Details and Assessment of Section 96(1A) Minor Modification for Central Barangaroo Waterfront Promenade and Interim Public Domain Works

The Authority has reviewed the minor refinements and has identified the need to submit an application under Section 96(1A) of the *Environmental Planning and Assessment Act 1979* (EP&A Act) to modify Development Consent to the State Significant Development for Barangaroo Central Waterfront Promenade and Interim Public Domain Works (Application Number: SSD12_5374).

# BARANGAROO | Promenade Section

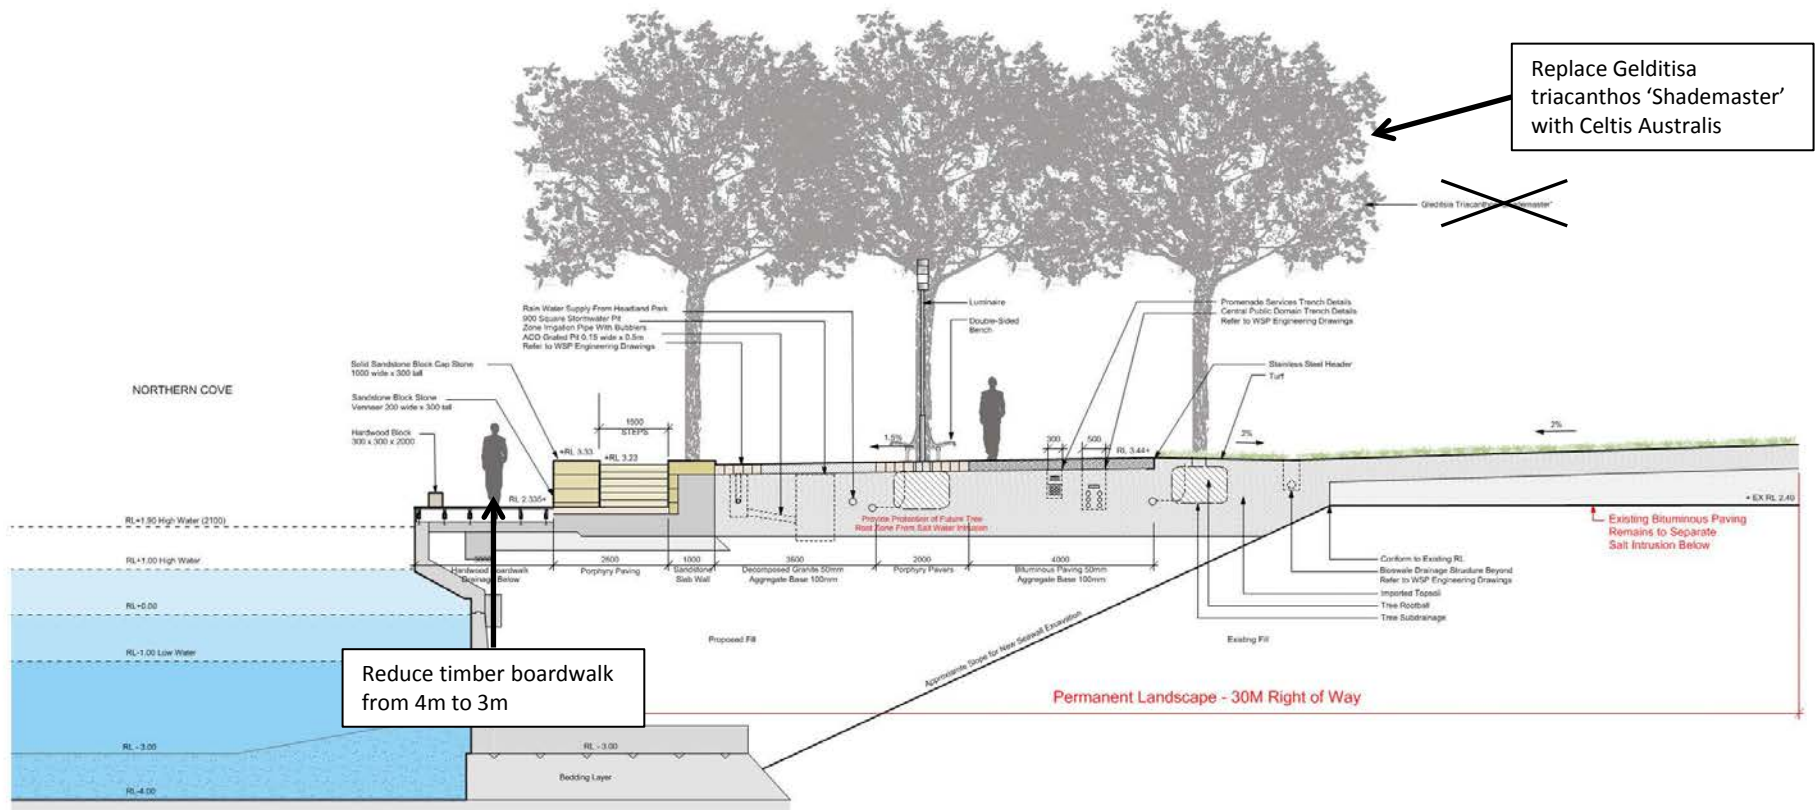
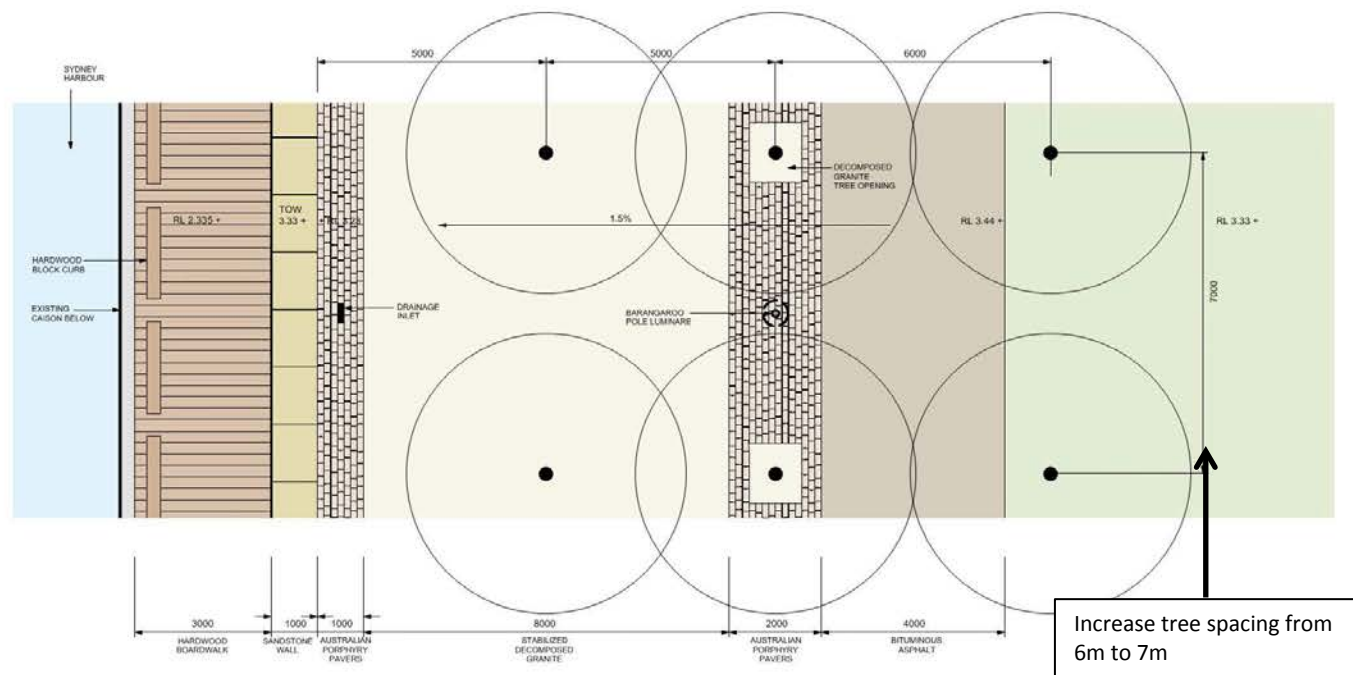
1. Reduction in timber boardwalk width from 4m to 3m to better integrate the Central Barangaroo and proposed Barangaroo South waterfront promenades;
2. Deletion of feature sandstone cladding on new seawall adjacent to the Public Deck in the Northern Cove as it is no longer required;
3. Increase tree spacing from 6m to 7m to resolve conflicts with outdoor furniture positioning;
4. Inconsistency with Condition B5 Paving Materials - the specified decomposed granite paving material along the promenade shown in the approved drawing set does not comply with the requirements of Condition B5 Paving Materials.
5. Change in promenade tree species to *Celtis australis* due to the current approved species, *Gleditsia triacanthos* “Shademaster”, being placed on the NSW Noxious Weed Order (February 2014) as a Class 3 Weed in the Sydney Region.

Proposed Change	Rationale for Change		Assessment of Potential Environmental Impacts
	Master Plan	Design Develop	
Waterfront Promenade (WP)			
Reduction in timber boardwalk width from 4m to 3m.	X		<p>No additional environmental impacts.</p> <p>This change has been driven by the coordination and integration of the Central Barangaroo and proposed Barangaroo South waterfront promenades.</p> <p>The reduction in width will not affect pedestrian flows as the timber boardwalk is a secondary pedestrian path with the primary pedestrian and cycle paths on the upper level remaining unaffected.</p>
Deletion of feature sandstone cladding on new seawall adjacent to the Public Deck in the Northern Cove.		X	<p>No additional environmental impacts.</p> <p>The 4m section of feature sandstone cladding on the new seawall adjacent to the Public Deck in the Northern Cove was proposed to hide a change in levels from the public pier to the waterfront promenade. The change in level has been designed out and therefore the feature sandstone cladding is no longer required to be installed. The profile and surface finish of the new seawall will now be continuous from the south western edge of the Northern Cove to the underside of the public deck.</p>

Increase tree spacing from 6m to 7m to resolve conflicts with outdoor furniture positioning.		X	<p>No additional environmental impacts.</p> <p>Tree spacing along the waterfront promenade has been increased from a width of 6m to 7m to resolve conflicts with positioning of outdoor furniture. This would improve public</p>

Revised Plan	Date of Plan	Name of Plan to be Replaced
Promenade Section	July 22, 2014	Promenade Section
Promenade Section at Northern Cove	July 22, 2014	Promenade Section at Northern Cove
Promenade Ramp and Public Deck	July 22, 2014	Promenade Ramp and Public Deck
Typical Paving Detail	July 22, 2014	Typical Paving Detail
